Site Audit Report Delineation and Characterisation Sampling and Review of Remedial Options Former Gasworks Site, Burren Street, Erskineville NSW

14 September 2007

RailCorp Safety & Environment Group

HLA-Envirosciences Pty Limited

Figure 2
Current & Historical Site Layout

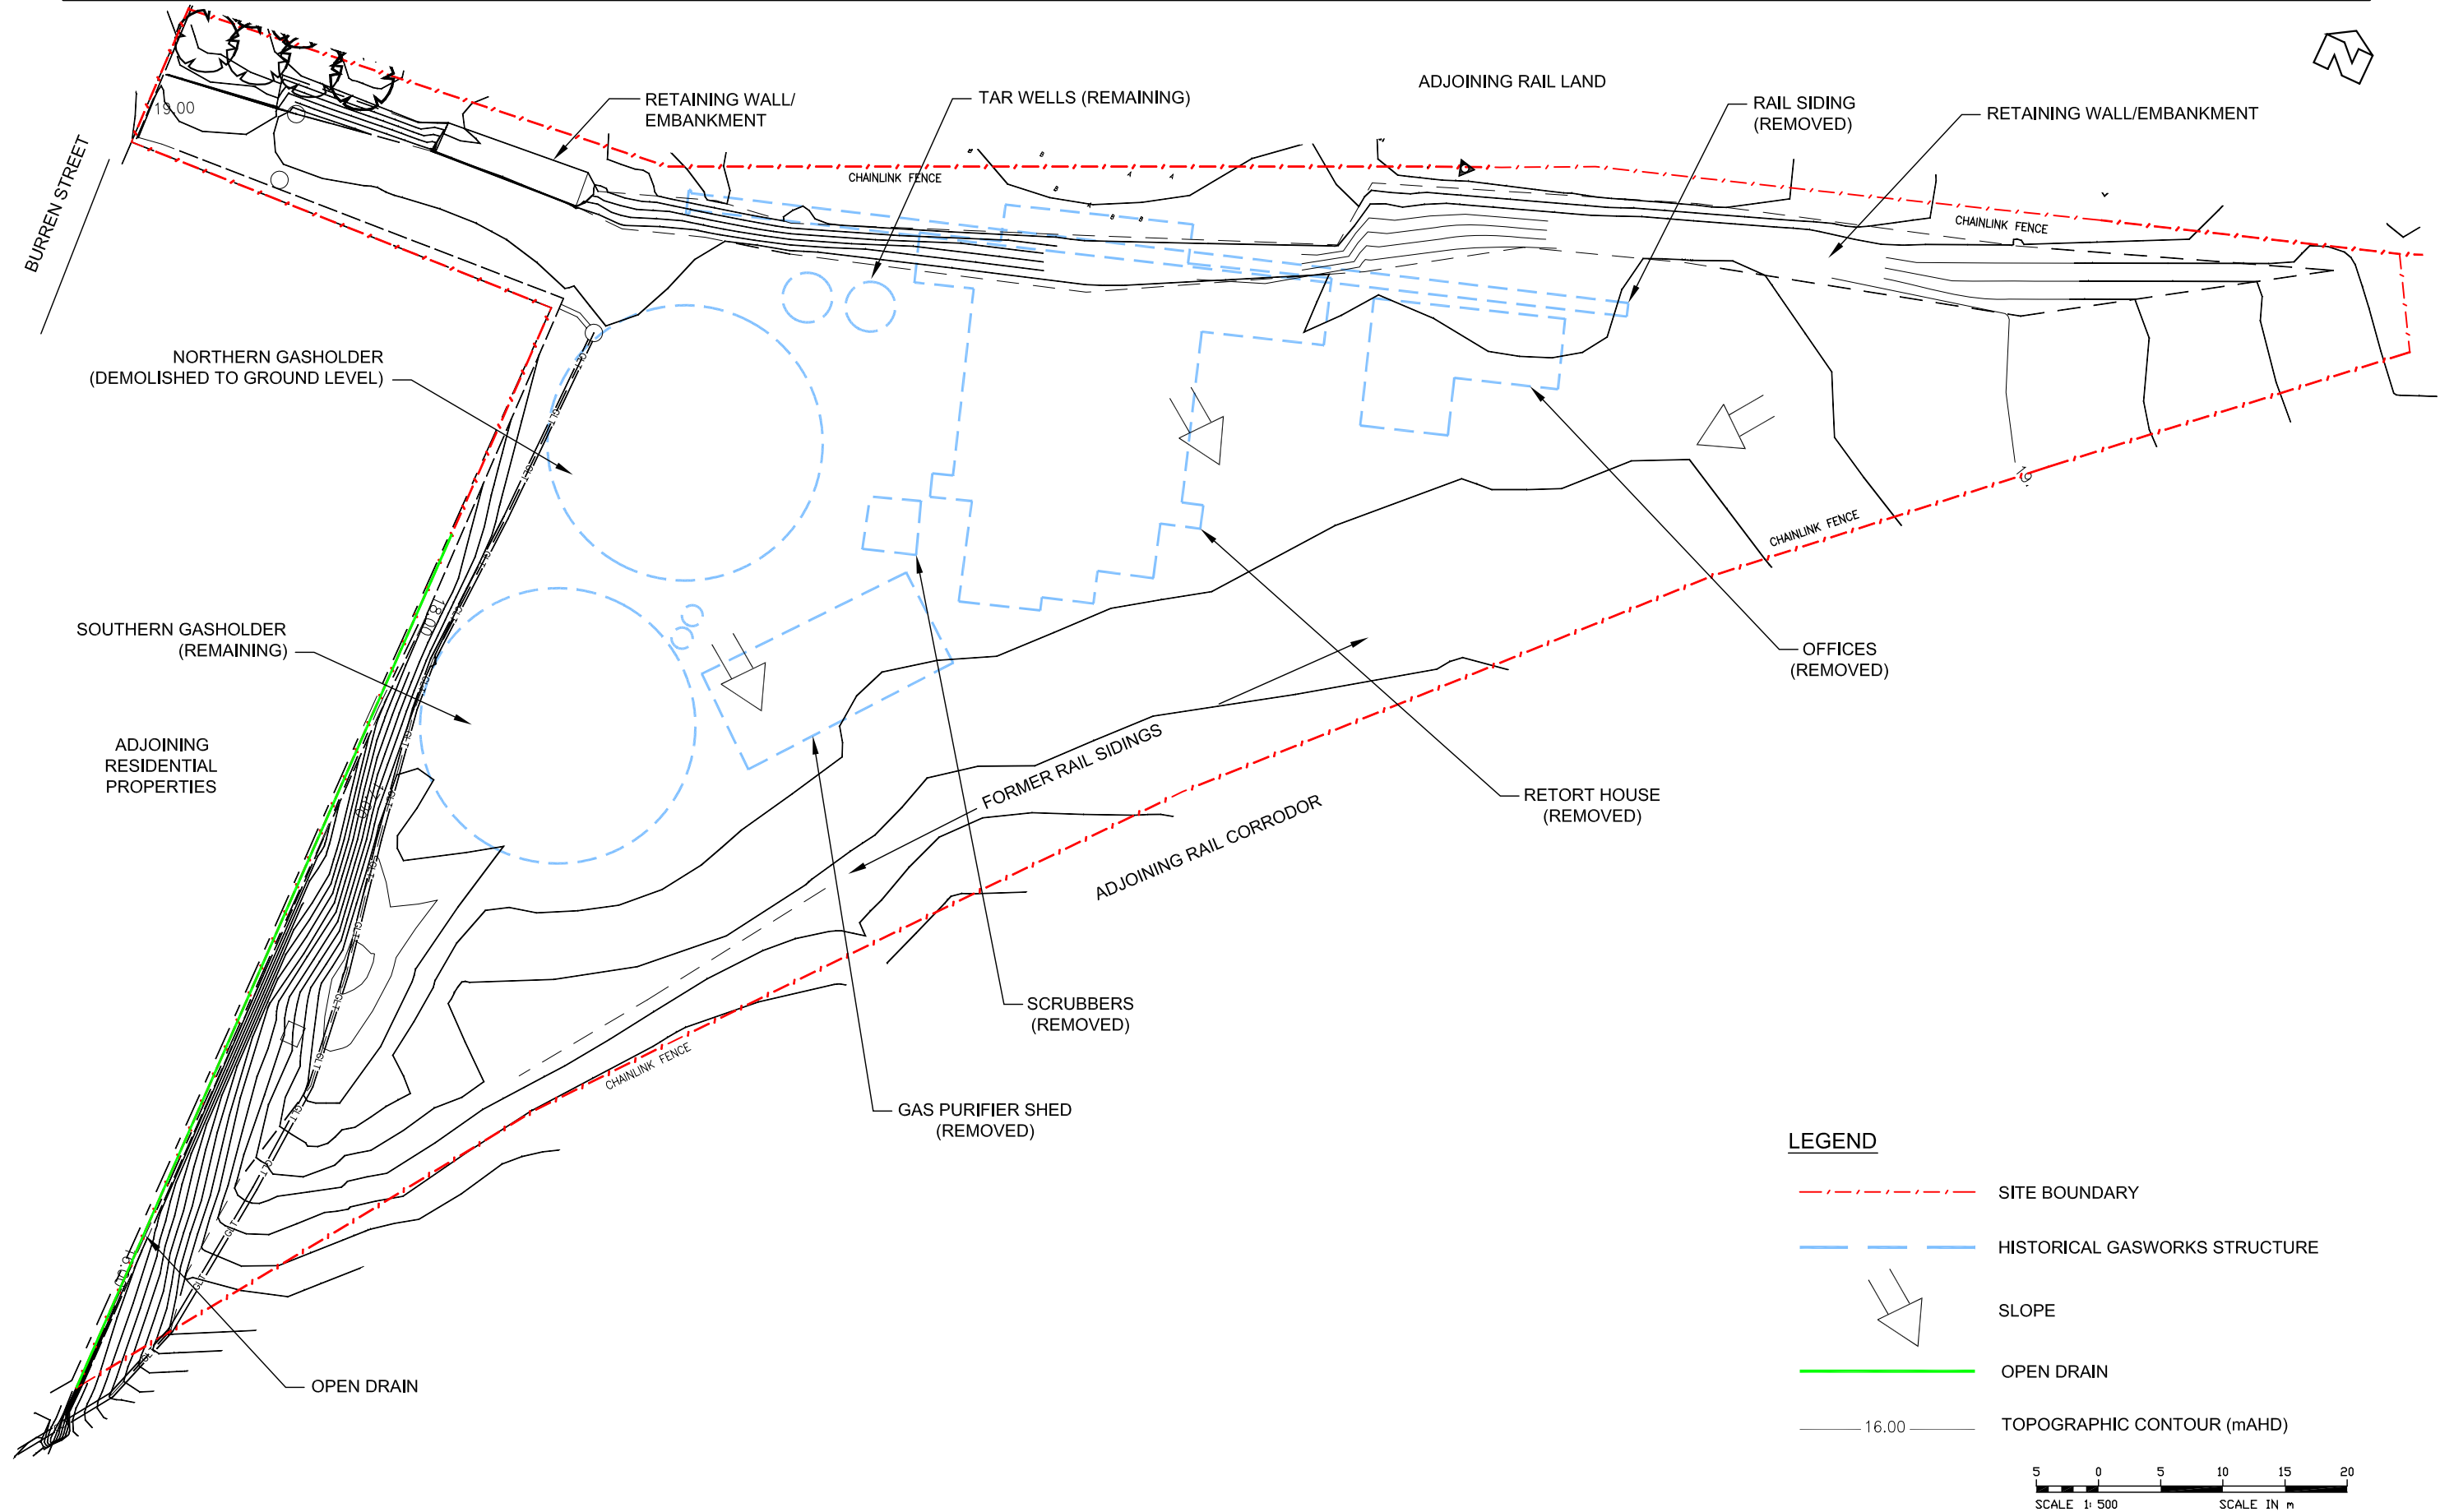
The Report stated that the Site has an area of 7732 m² and is triangular in shape, as shown on Figure 2 (Attachment 1).

- Facilities and buildings present on the Site during the operation of the MGP included a retort house, an exhauster, a boiler, condensers, purifier beds, a scrubber, two tar wells, above ground tar tanks, a gas meter, two gasholders, service pipework, raw store areas, compressors and other buildings including offices and washrooms. A railway corridor consisting of three rail lines ran along the south-eastern boundary of the Site and a single rail line ran along the northern boundary of the Site. The historical layout of these facilities is presented on Figure 2 (Attachment 1);
